**WELWYN HATFIELD BOROUGH COUNCIL
EXECUTIVE DIRECTOR - PLANNING, PUBLIC PROTECTION AND GOVERNANCE**

DELEGATED APPLICATION

Application No: 6/2019/0605/HOUSE
Location: Just House Coopers Lane Northaw Potters Bar EN6 4NJ
Proposal: Alteration to roof design
Officer: Ms Lucy Hale

Recommendation: Refused

JUST HOUSE, COOPERS LANE, EN6 4NJ - EXISTING NORTHERN AND WESTERN ELEVATIONS - SCALE 1:100

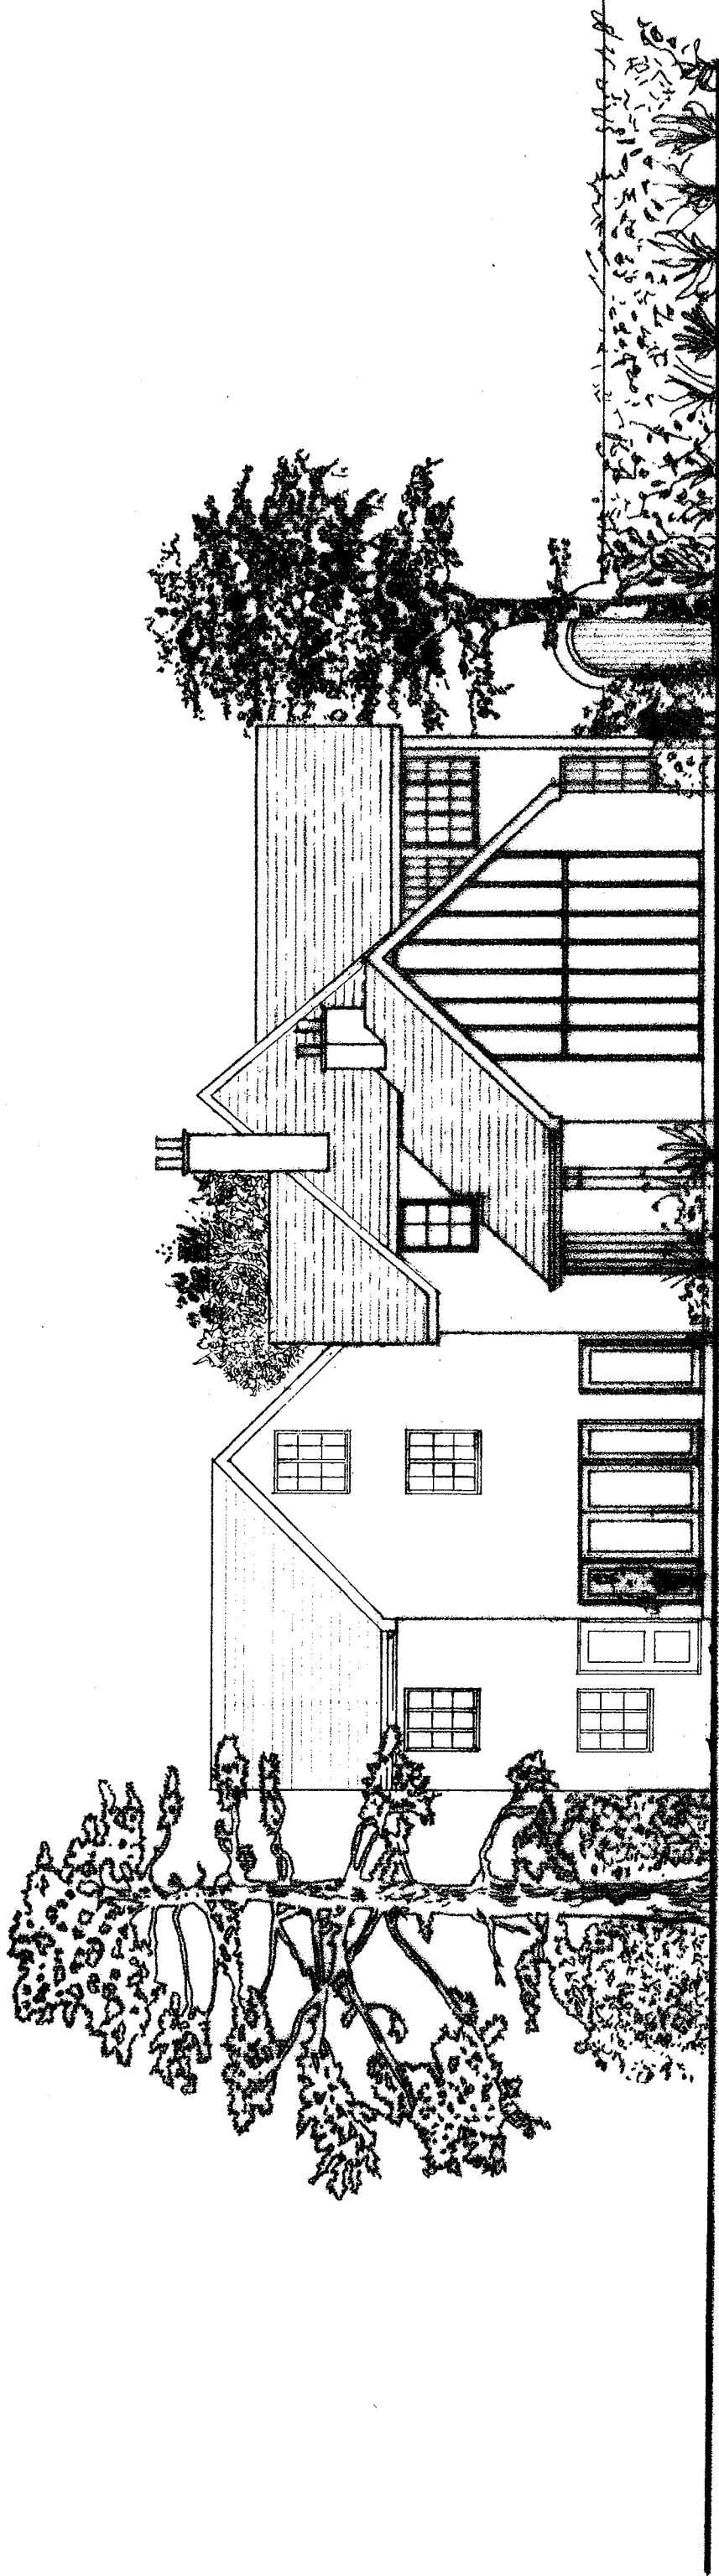
The proposed crown roof design would continue the ridge height of the existing dwelling and would project 6 metres in width by 6.4 metres in depth. The roof addition would add substantial bulk and mass and would overwhelm the original scale of the roof, failing to appear subordinate. Furthermore, the existing valley to be infilled assists the side extension appearing subservient to the original dwelling. The existing side extension, approved side extension and proposed roof additions would, cumulatively, appear substantial and amount to additions that would overwhelm the original dwelling resulting in harm to the appearance of the dwelling and character of the streetscene.

To the front of the dwelling, the roof connecting the original dwelling and side extension currently has a lower ridge height. This would increase in height to meet the ridge height of the main dwelling and would follow the same pitch. To the rear, the crown roof would extend up to the approved gable end side extension. Flush tiling is proposed on the rear elevation to infill the resultant space. There is also an existing gable projection which is set lower in height than the main ridge of the dwelling and the approved side extension, and it extends further to the rear. The existing projection and approved two storey side extension would join and form a right angle at the eaves. However, as a result of the height comparison and siting, a section of roof is suggested to adjoin this projection to the crown roof which would result in an awkward pitch. This element is considered to fail to relate to the existing pitched roof and would appear at odds. The various angles and pitches and tiled flush finish are all considered to result in the intersection appearing contrived and fussy. This lends to poor quality design which would detract from the appearance of the dwelling and the character of the area.
